Recommendation Report for Planning Permission for Works or Extension to a Dwelling

REF NO: EP/30/26/HH

LOCATION: 3 Boundary Way
East Preston
BN16 1BU

PROPOSAL: Side extension and rear extension.

GROUND FLOOR PLAN

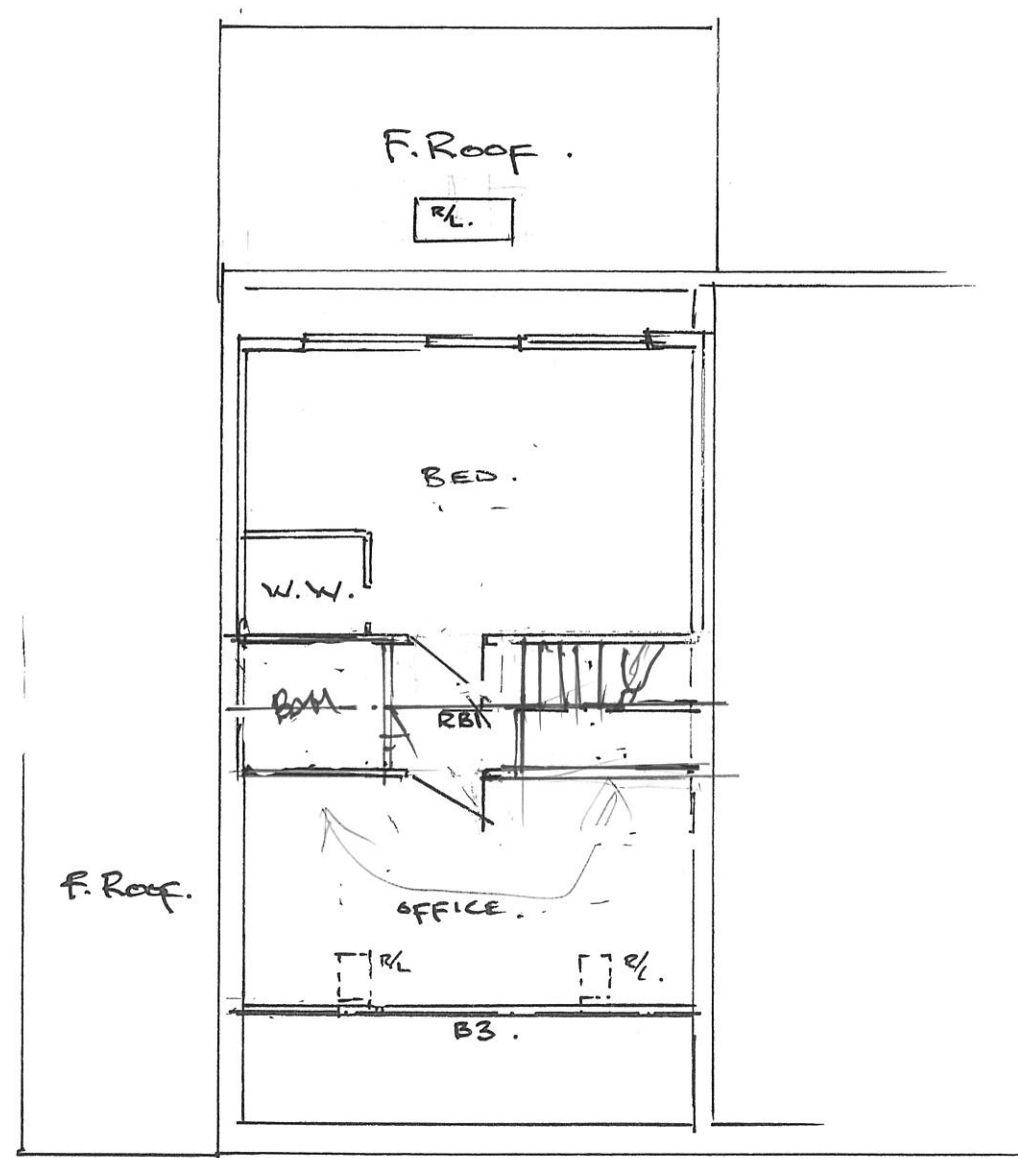
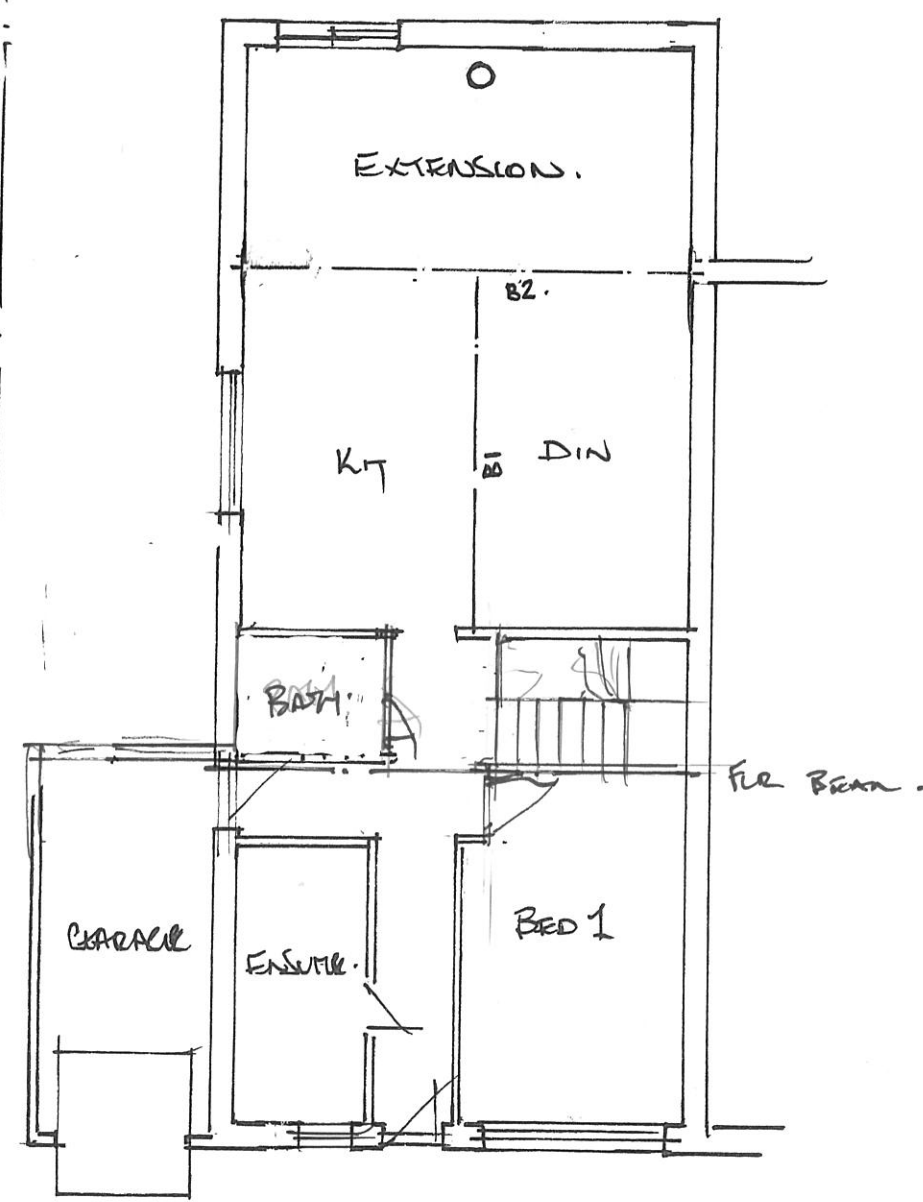
Concerns regarding the accuracy and quality of the plans are acknowledged, and extensive communication has taken place with the agent to address these matters. Final amended plans were submitted on 17 July 2026. These amended plans have reinstated the rear dormer, which had previously been requested to be removed, and state that it would be constructed under permitted development. The 17 July submitted plans also show two front rooflights; the rear dormer and front rooflights do not form part of this application.

The site is a semi-detached bungalow at 3 Boundary Way. This application seeks permission for a single-storey rear extension, a single storey side extension accommodating a garage to the northern flank elevation, and the relocation of the front door to the western elevation. The submitted plans also show a rear dormer and two front rooflights; these do not form part of this application.

The proposed single storey rear extension would be set in 3m from the northern side boundary and 6m from the rear eastern boundary. It would abut the southern neighbouring boundary but would not extend beyond the neighbouring extension. Given the existing boundary treatment, flat roof design, and modest height, it would not result in overshadowing or overbearing impacts to neighbouring properties.

The proposed garage extension would be set back 7.75m from the western front boundary, 12.3m from the eastern rear boundary, and 0.15m from the neighbouring northern boundary. Although, this would not comply with the minimum 1m side boundary guidance as outlined in the Part M of the ADG, the garage would abut the neighbouring detached garage. Given its flat roof design and modest height, the proposal would not result in overshadowing or overbearing impacts to neighbouring properties.

Part I of the ADG requires dwellings of two to three bedrooms to provide a minimum of two parking spaces. Although the proposal includes the construction of a garage with an approximate depth of 5.5m and an approximate width of 2.5m it fails to meet current garage dimensions of 3m width and 6m depth and would therefore be considered inappropriate to accommodate a vehicle. However, the front driveway has sufficient capacity to accommodate this requirement with a width of 9.6m and a depth of 7.75m, allowing for the minimum requirement of two off-street parking spaces.

- 4 INFORMATIVE: This application does not include the proposed loft alterations including a rear dormer and front roof lights. The applicant must ensure that any such development either complies with the General Permitted Development Order 2015 (England) (as amended) or is the subject of a separate planning application, as appropriate.
